F PLANNING REPORT

Belvor Close, Spalding, Lincolnshire. PE11 3FZ

Planning Reference H14-0391-21

Erection of chill store, collation, loading dock together with offices, self store containers and car parking.

Section

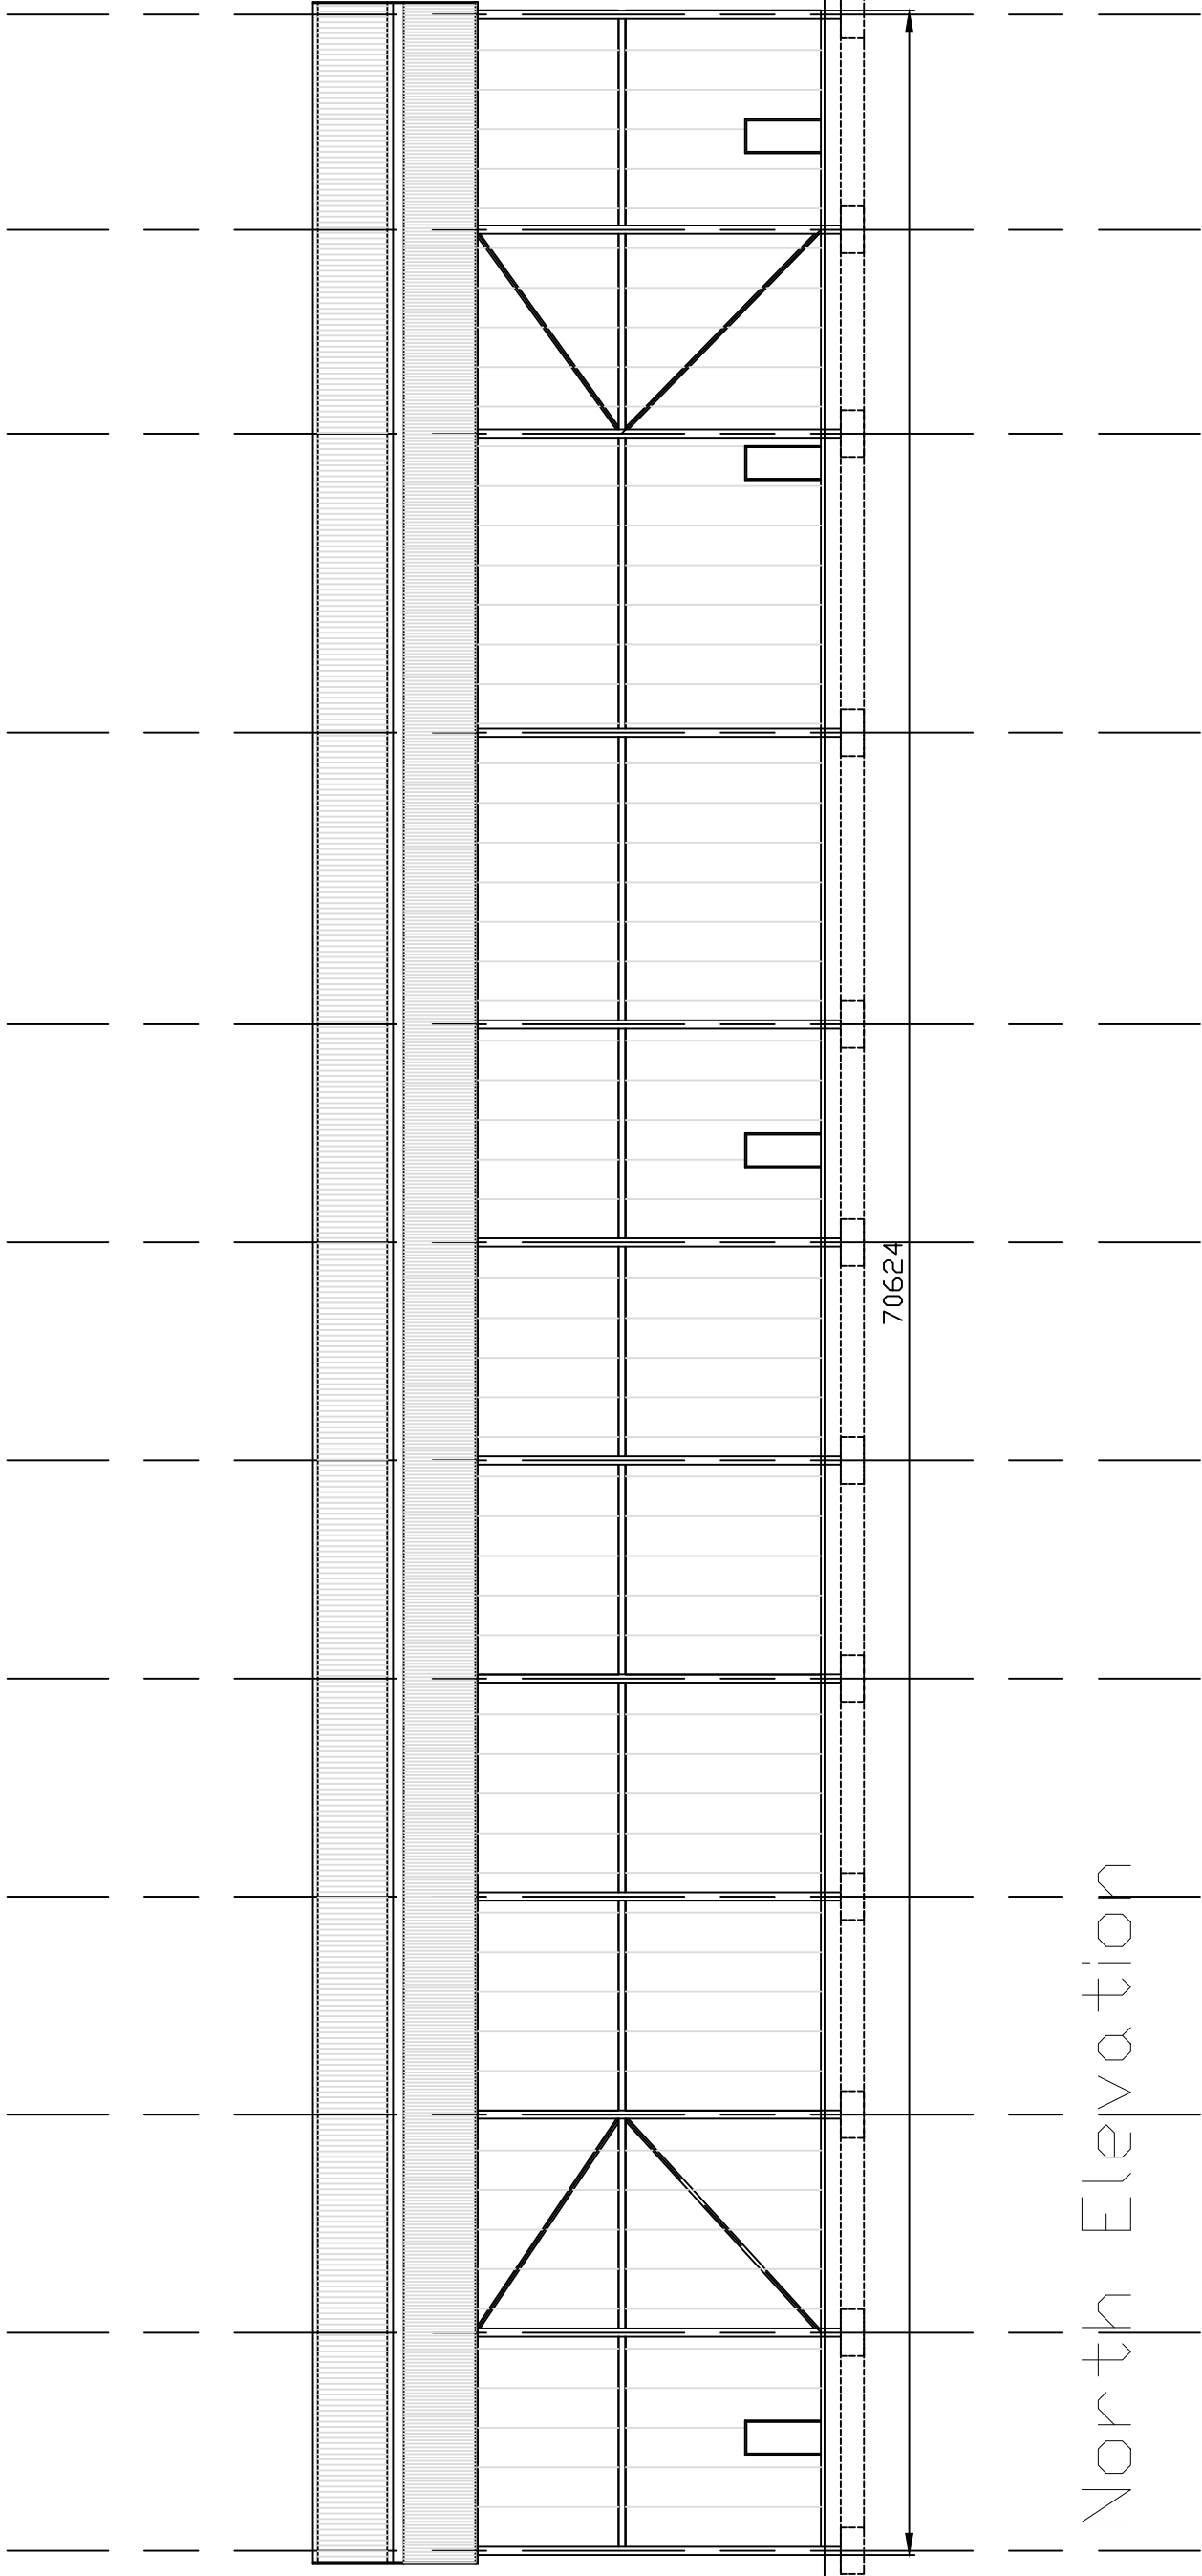
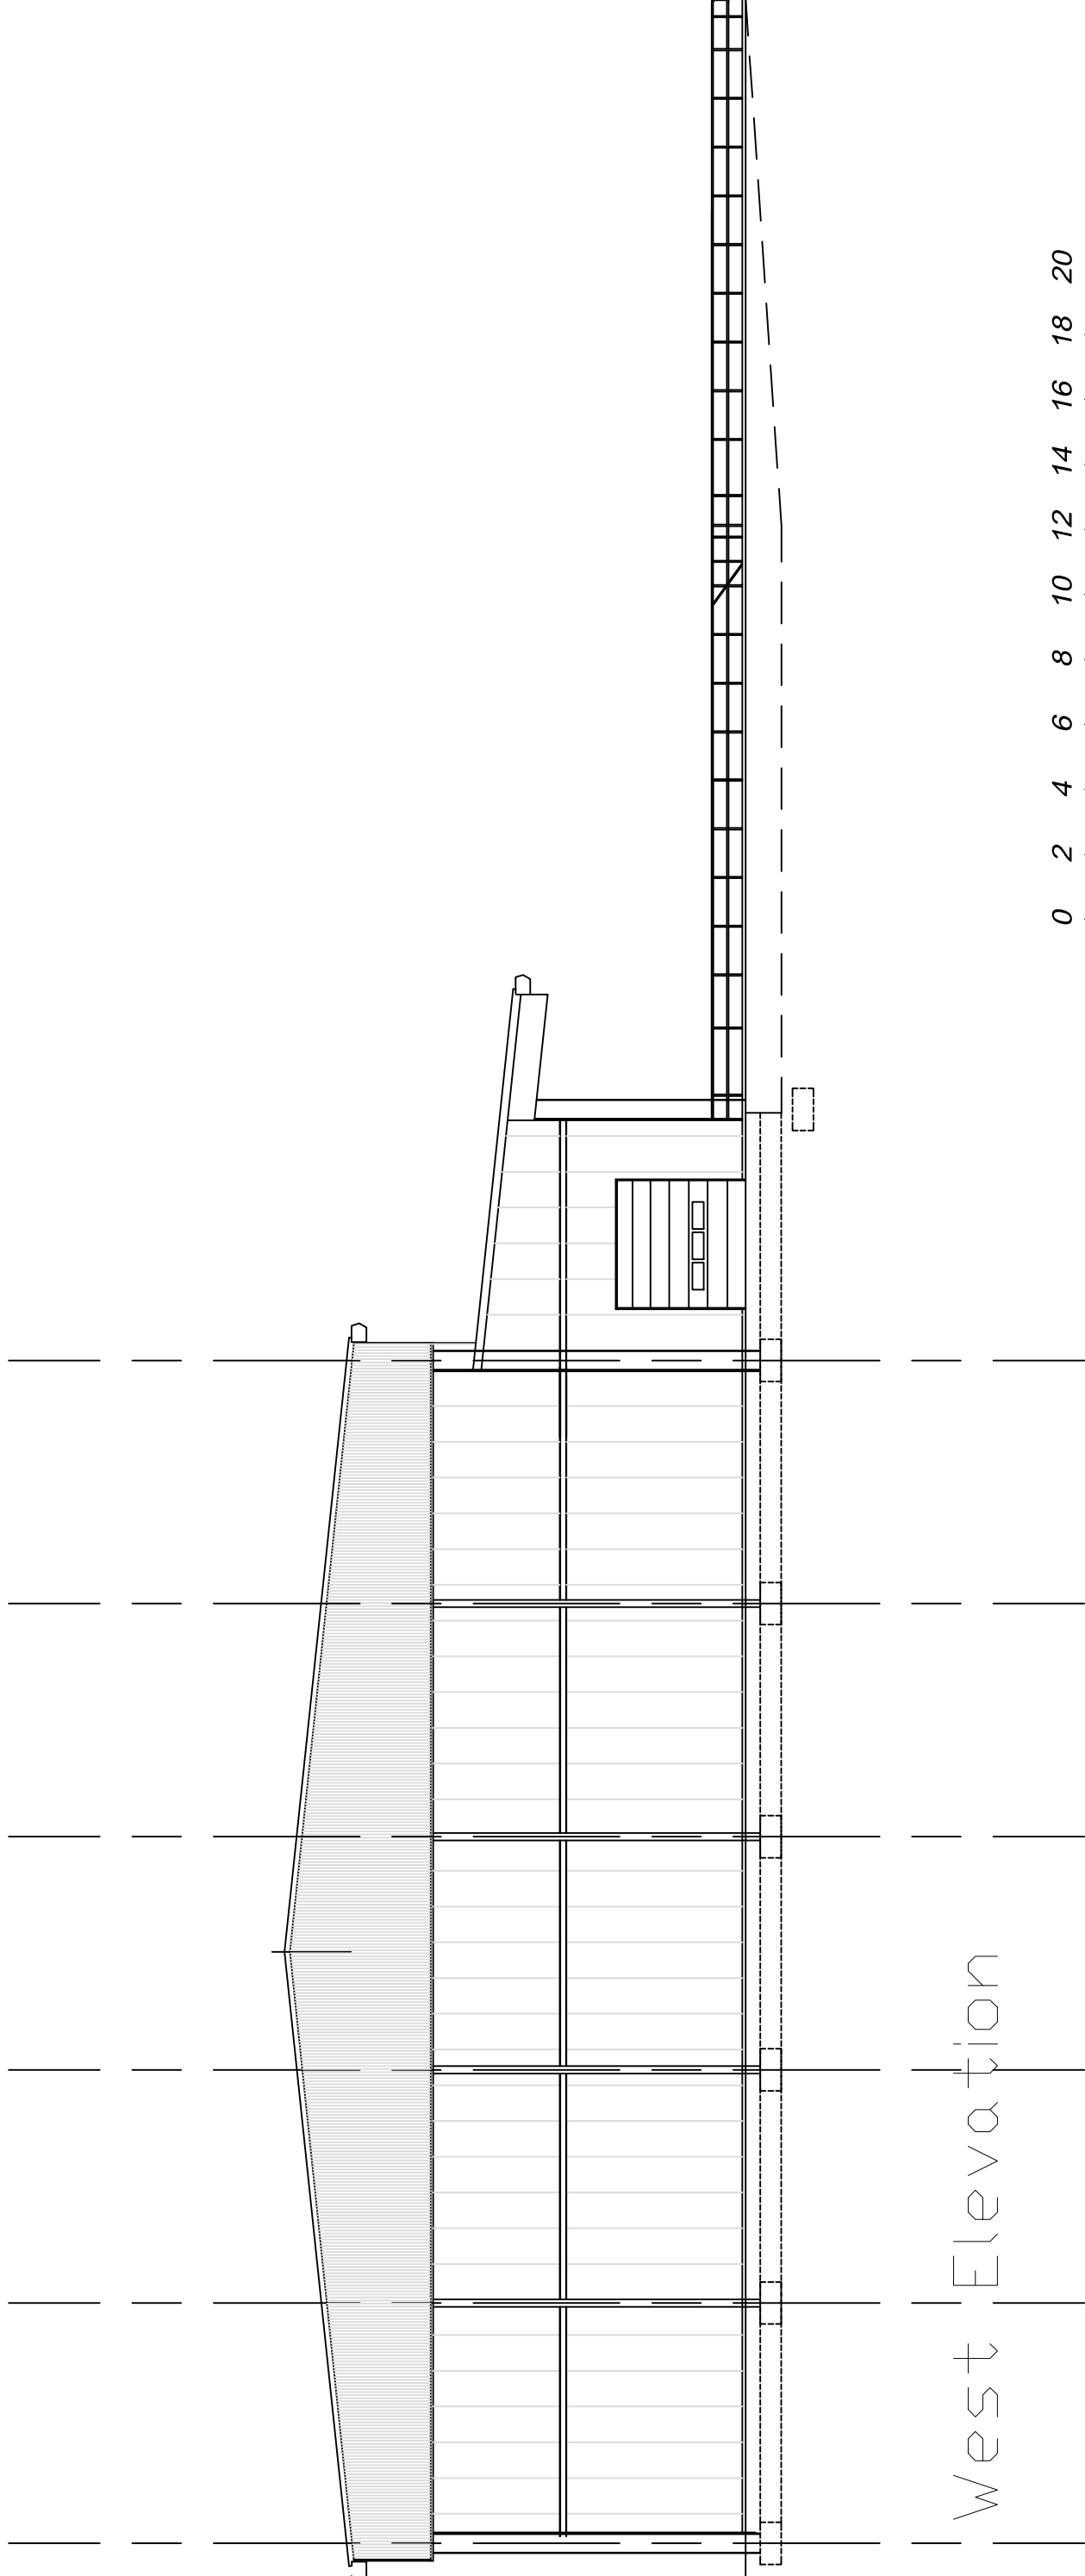
We are aware of local flood risk and standing advise in relation to floor levels however floor levels need to be practical and we have adopted our approach on this basis the proposal of 3.150m ODN floor level is actually 250mm higher that the existing buildings on freshlinc site which is 2.900m ODN. This is as high as we believe is practicable given the interaction of site operations. Raising the floor levels further is not an available option. Consideration given to preventing flood water entering the building is also not practical as the projected depths of 0.5 to 1.0 m would cause structural damage to walls and loading docks are impossible to water seal.
